SUBJECT: SFD2506-0086
SINGLE FAMILY DWELLING

Here are the results of all Inspections located at **374 PEACH FARM RD**:

FIRST FLOOR
PLAN

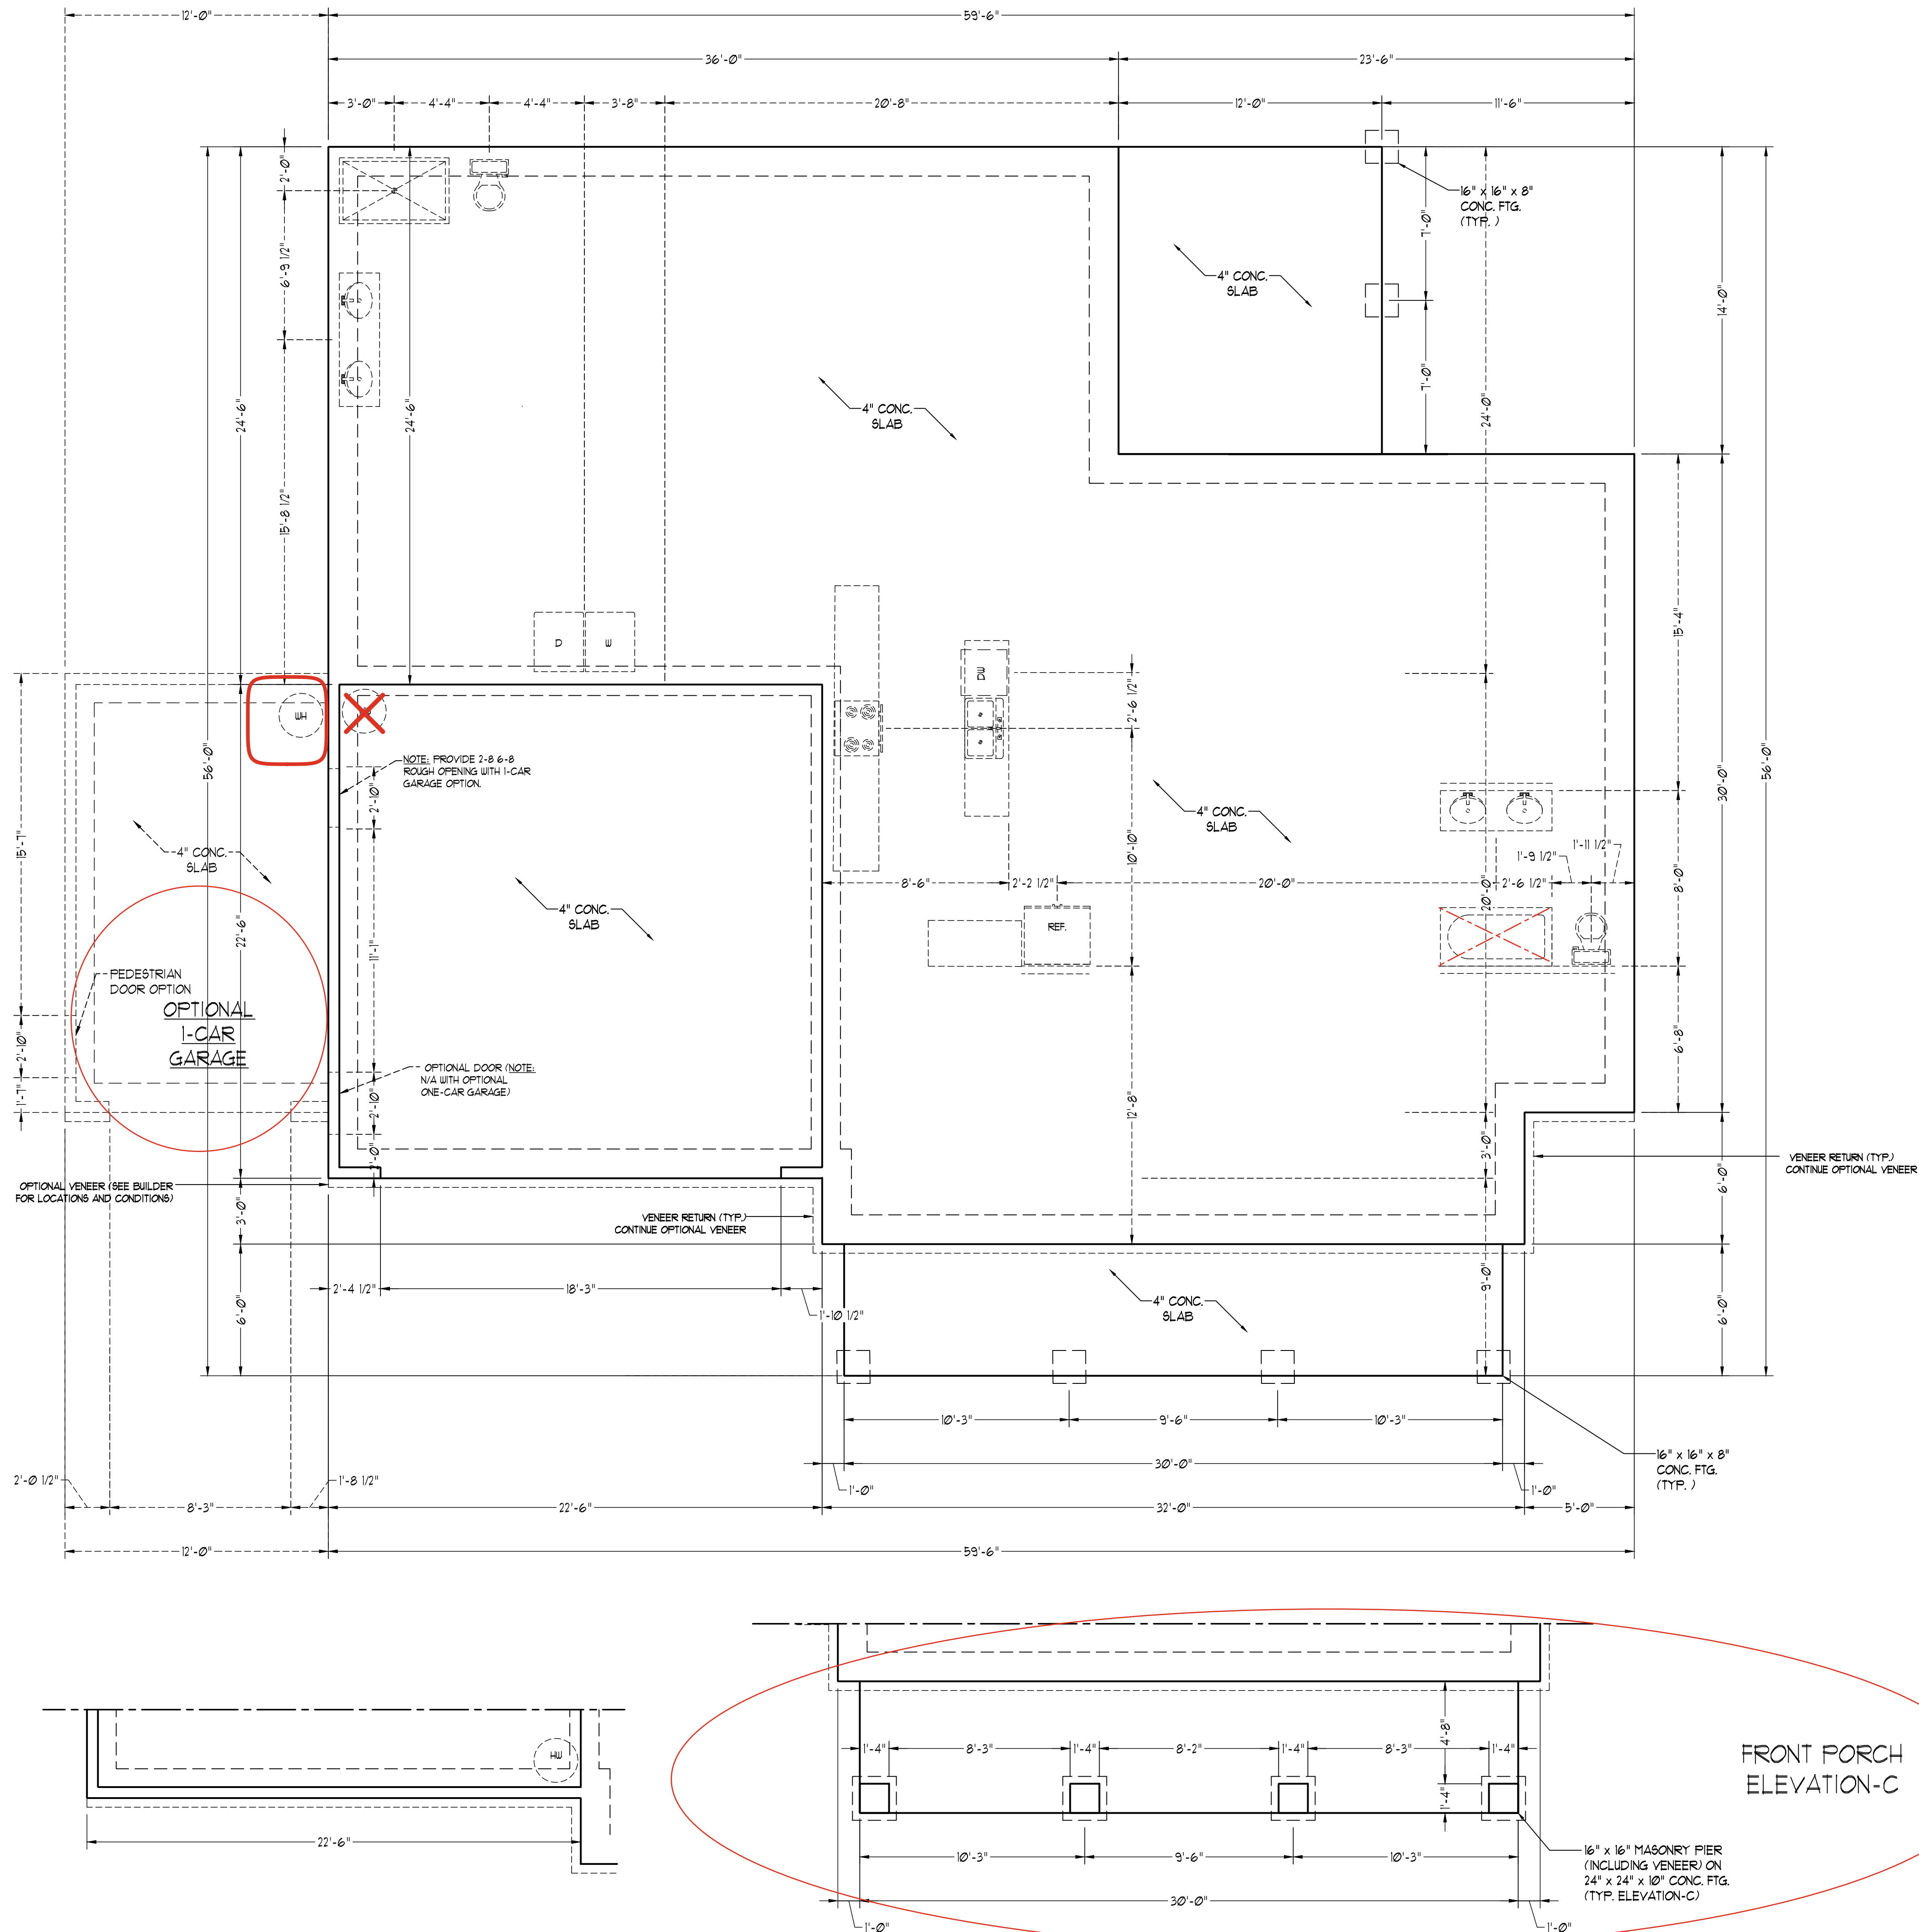
Inspection Type: ROUGH IN
Scheduled Date/Time: 9/10/2025
Completed Date/Time: 9/10/2025
Inspector: Deen Taylor
Result: DISAPPROVED
Remarks:
Notes: Install insulation and air barrier at master tub shower seat. OK to insulate.
